NSW RURAL FIRE SERVICE

Your reference: SSD-13855453
Our reference: DA20210208000486-EIS & DA
Exhibition-1

State Significant - EIS & DA Exhibition - Industry

Grenfell Poultry Breeder Farm 1130 Gooloogong Road Grenfell NSW 2810, 22//DP866857

Appendix A - Bush Fire Management Plans

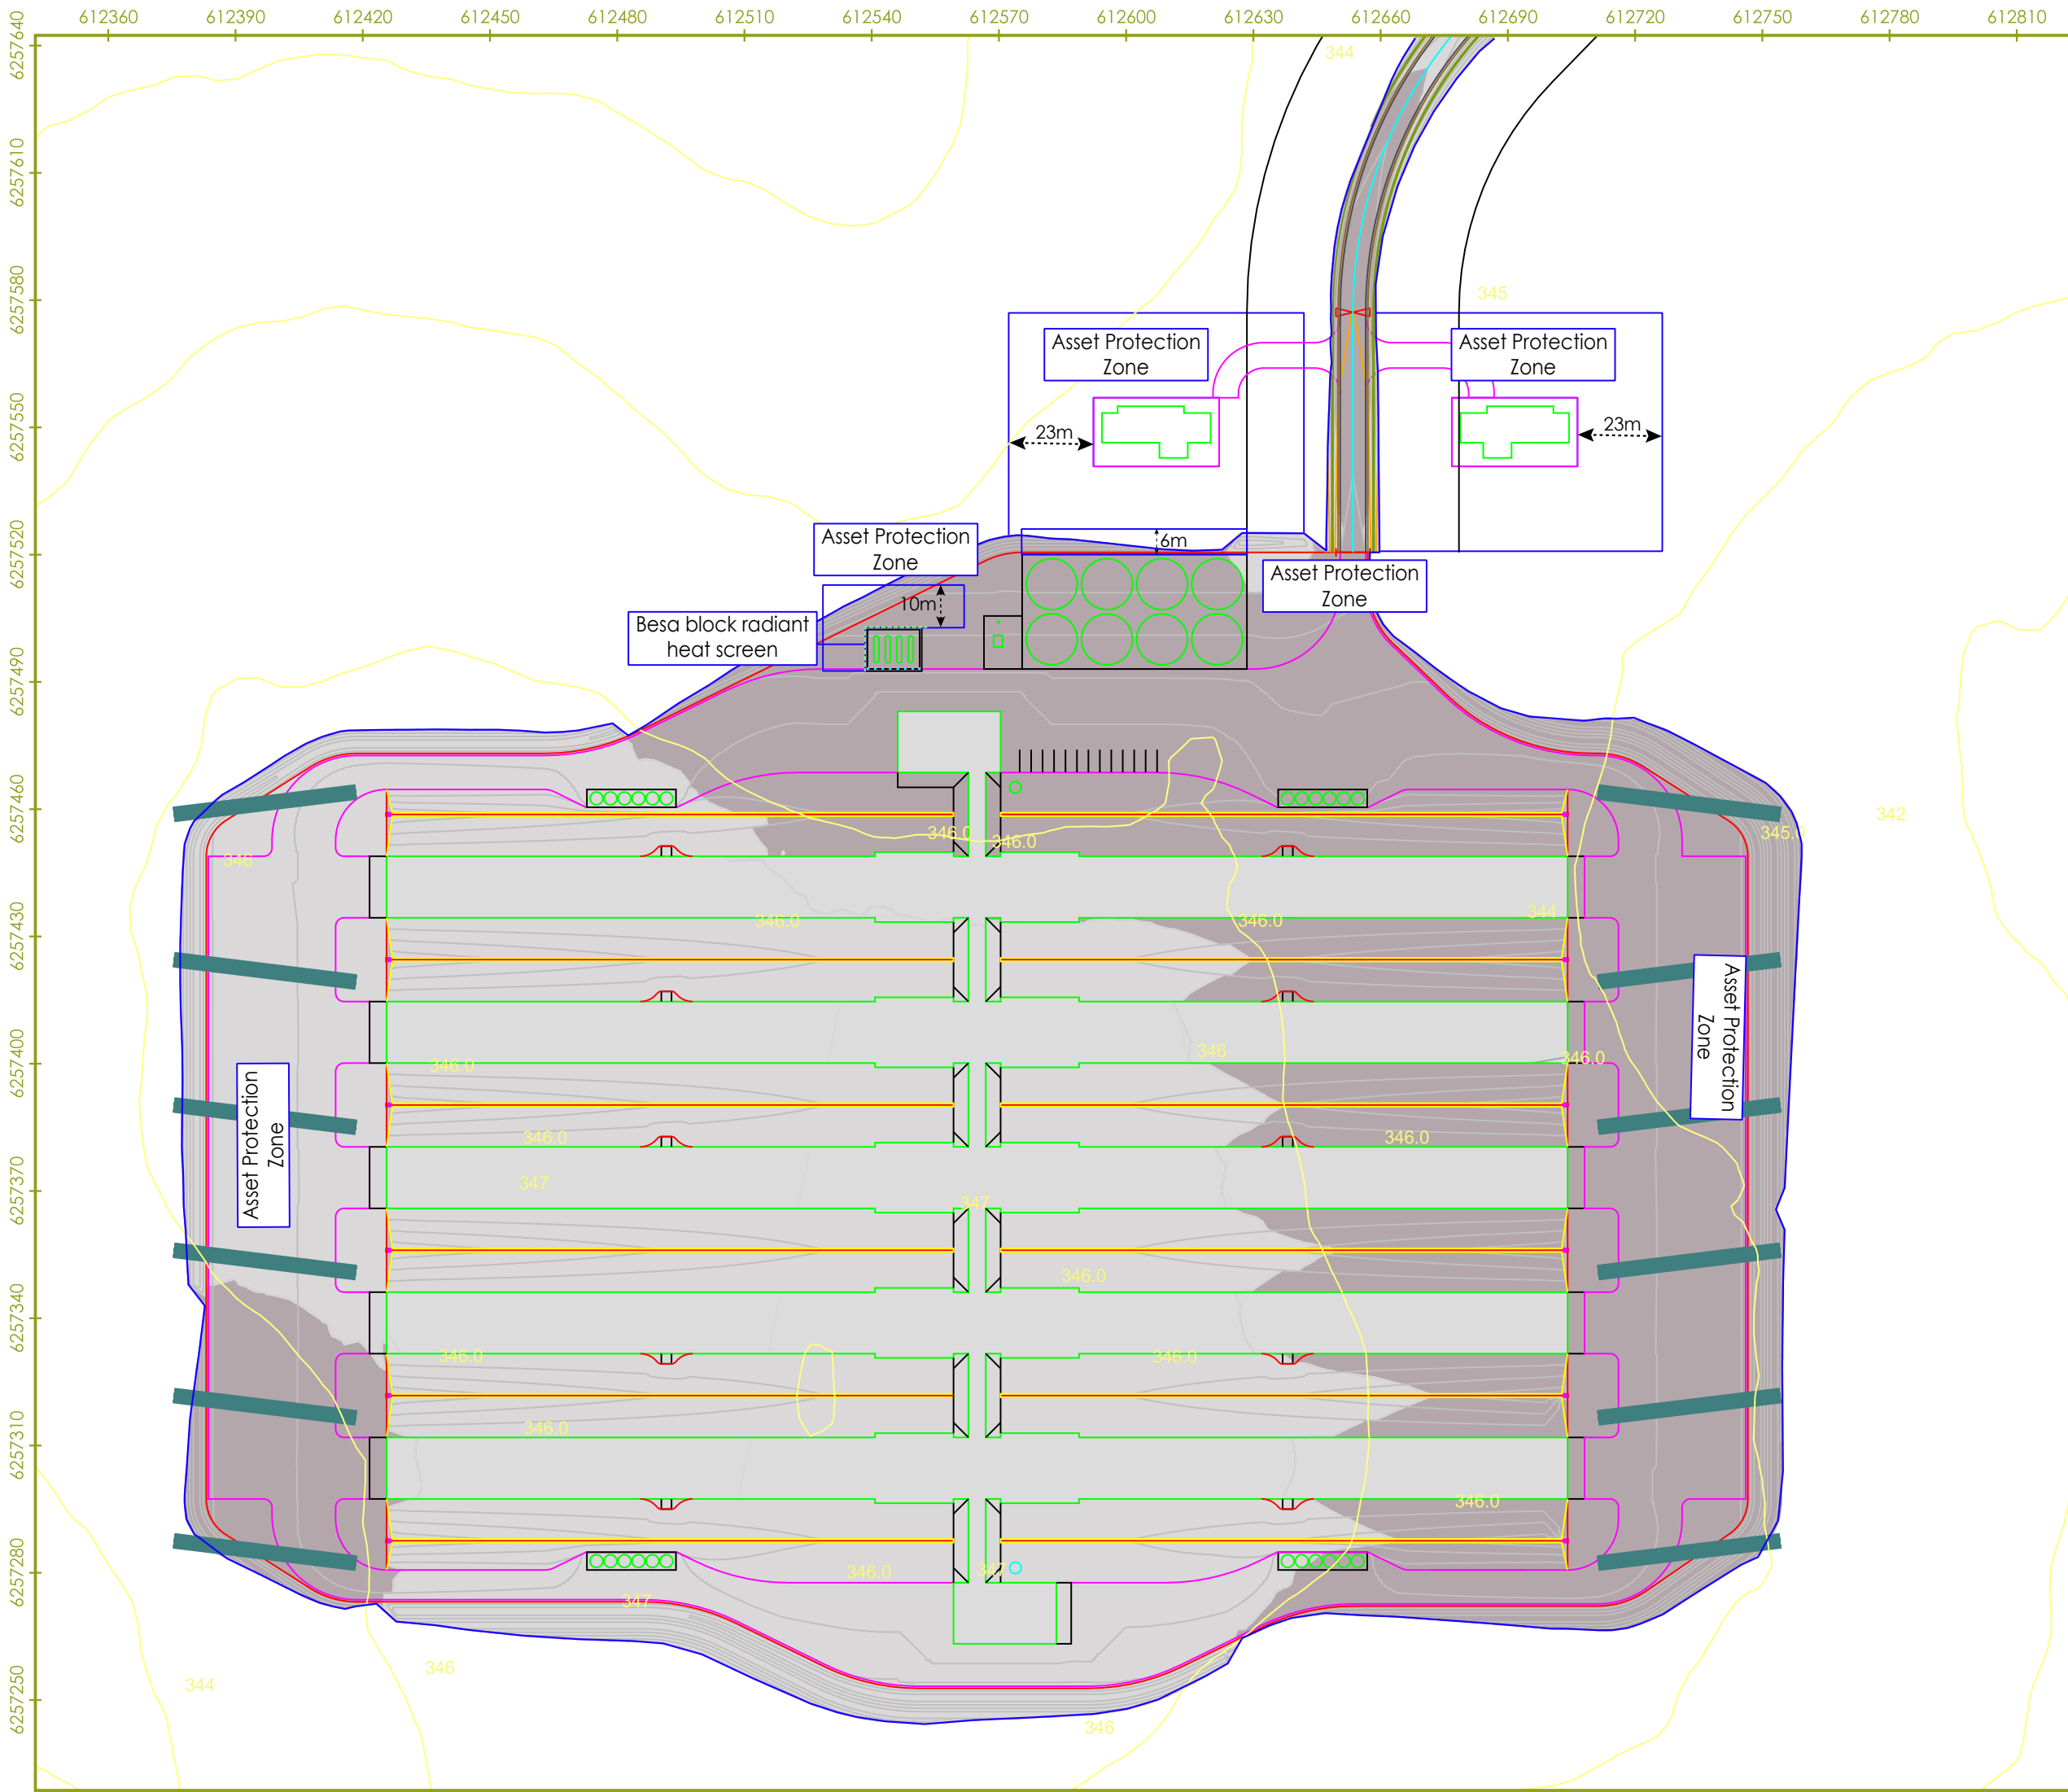
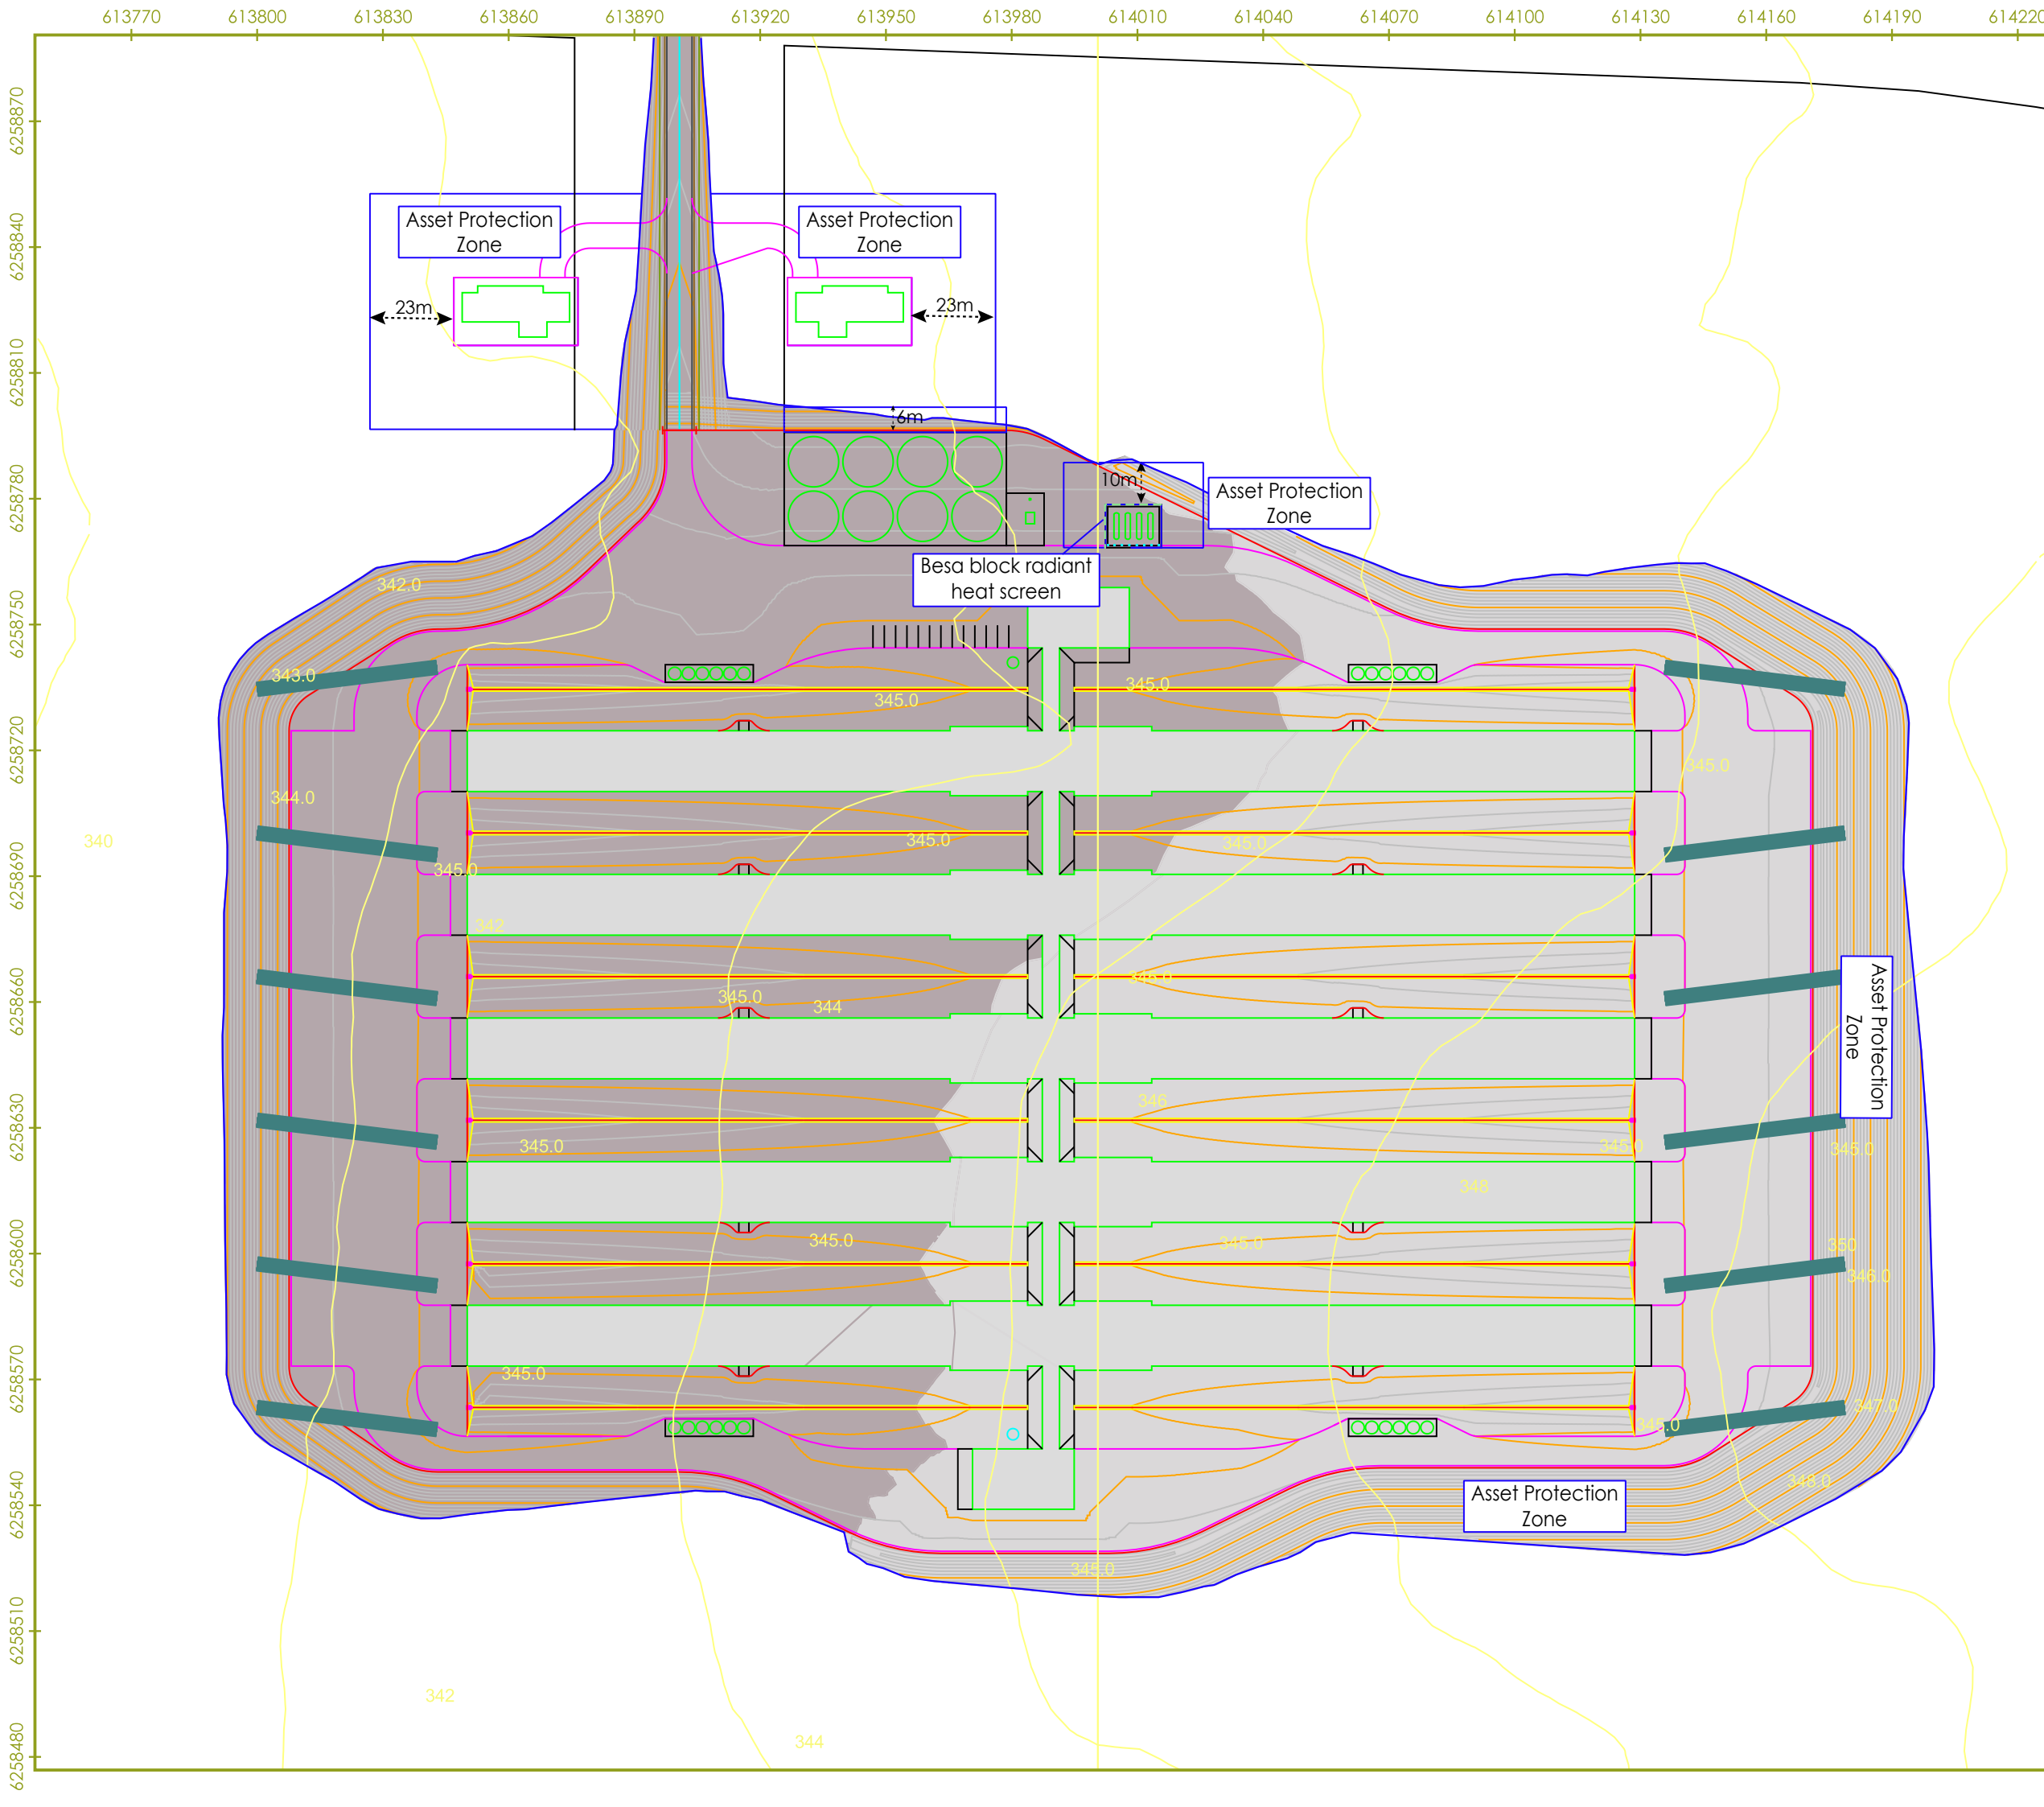
2. From the commencement of building works for each individual building, and in perpetuity to ensure ongoing protection from the impact of bush fires, asset protection zones must be provided around the facility buildings and residential building as identified in the 'Bush Fire Management Plan' prepared by Meridian Urban Pty Ltd (*Bush Fire Hazard Assessment and Management Plan*, dated 8 October 2021, Project Ref: 21-005, Rev. A). the asset protection zones are to be managed entirely as an inner protection area. When establishing and maintaining an inner protection area the following requirements apply in accordance with the requirements of Appendix 4 of *Planning for Bush Fire Protection 2019*:

5. A minimum 1.5 metre high radiant heat shield made of non-combustible materials must be constructed around the proposed LPG storage tanks, as identified in the 'Bush Fire Management Plan' prepared by Meridian Urban Pty Ltd (*Bush Fire Hazard Assessment and Management Plan*, dated 8 October 2021, Project Ref: 21-005, Rev. A). All posts and rails shall be constructed of steel. The bottom of the shield is to be in direct contact with the finished ground level or plinth.
